Hearing Transcript

Project:	Morgan and Morecambe Offshore Wind Farms Transmission Assets
Hearing:	Issue specific hearing 1- Part 2
Date:	30 April 2025

**Figure 4.2: Landfall Area of Search**

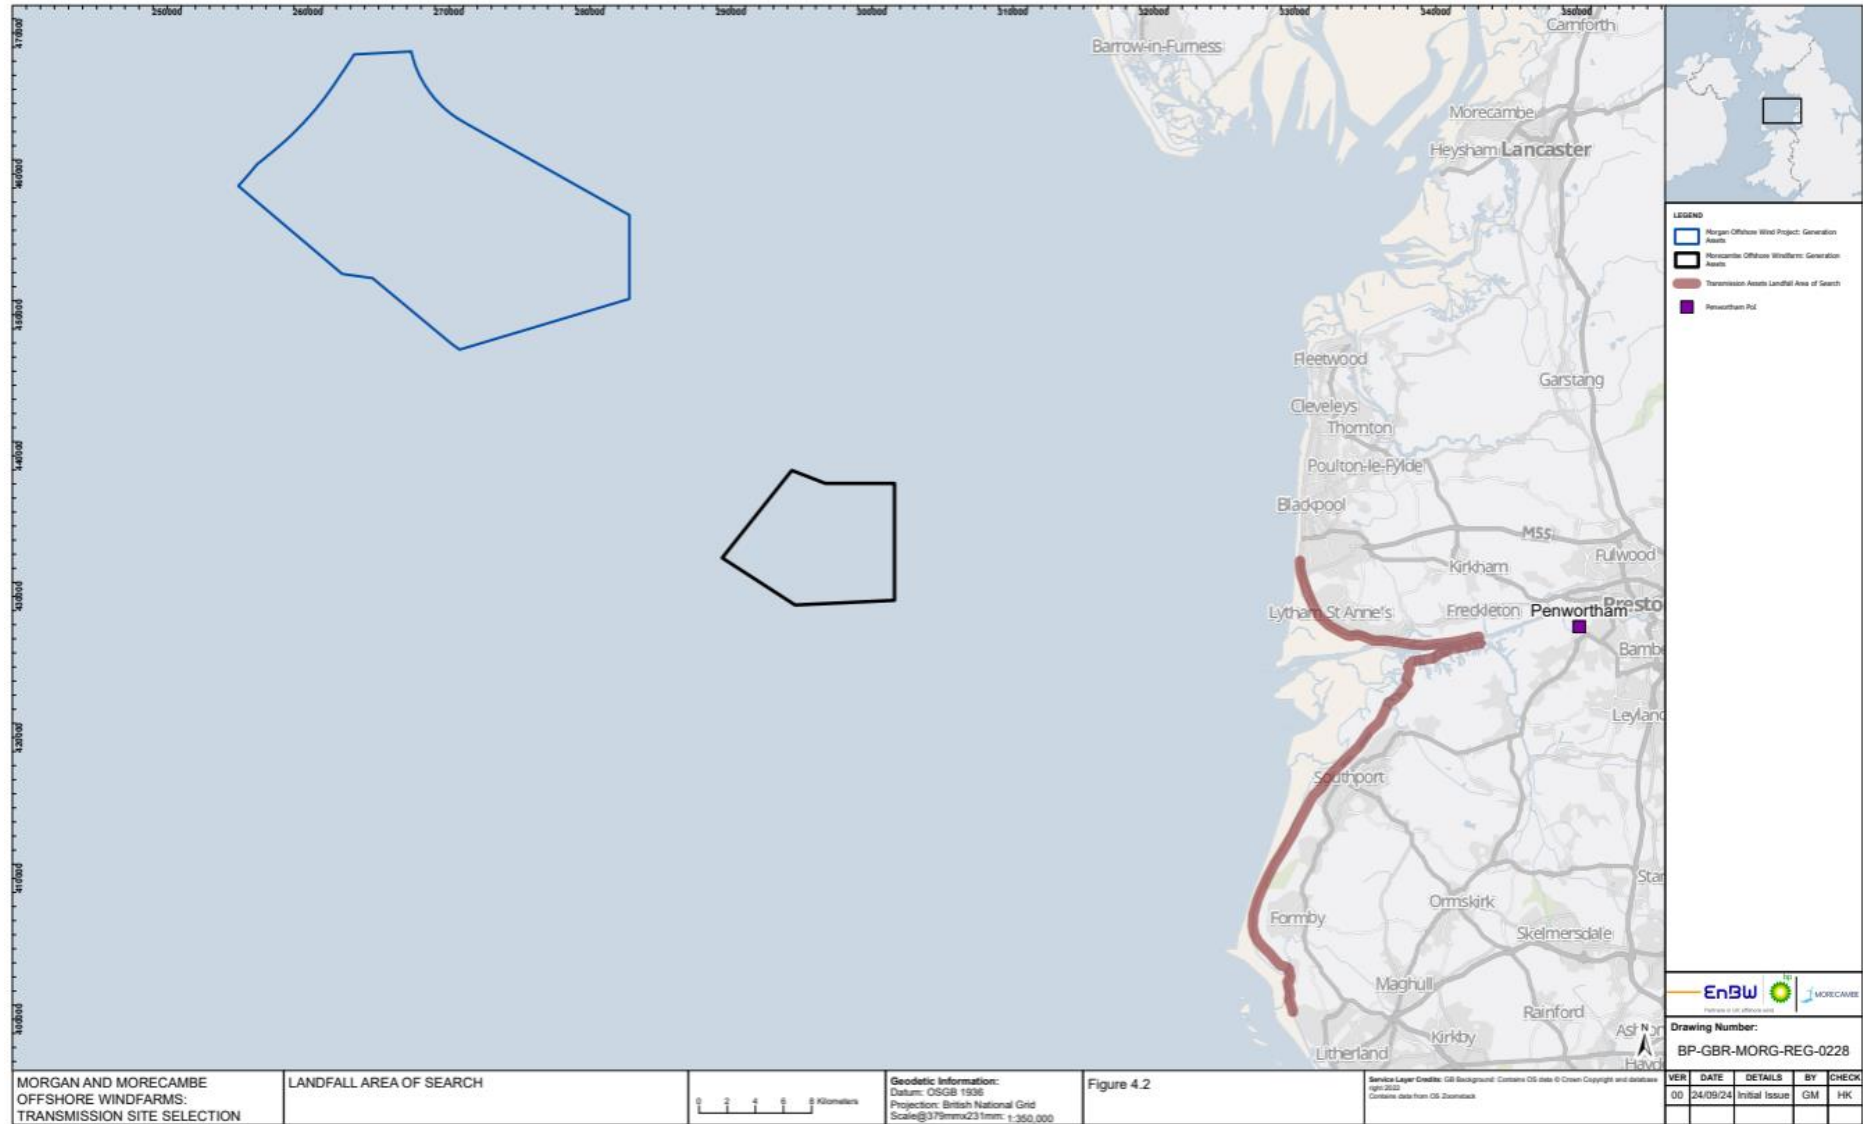
The landfill search in this case which is relevant to the to the grid connection. I might be jumping around a bit here. So. So bear with me. Which figure? Figure 4.2 of annex 4.1 of volume one of the ES. You can put it up if you want to. Um, it's figure 4.2 of annex. It's app 033. I think this might take longer to get to. Then I think for the next issue specific hearing, we will try harder to give you references. This one was debatable if it was needed or not. Um, we will for the next one.

I'll ask the question anyway. Is that the landfill search area identifies an approximately 50km range of coastline extending up to the urban area of Blackpool, but not beyond.
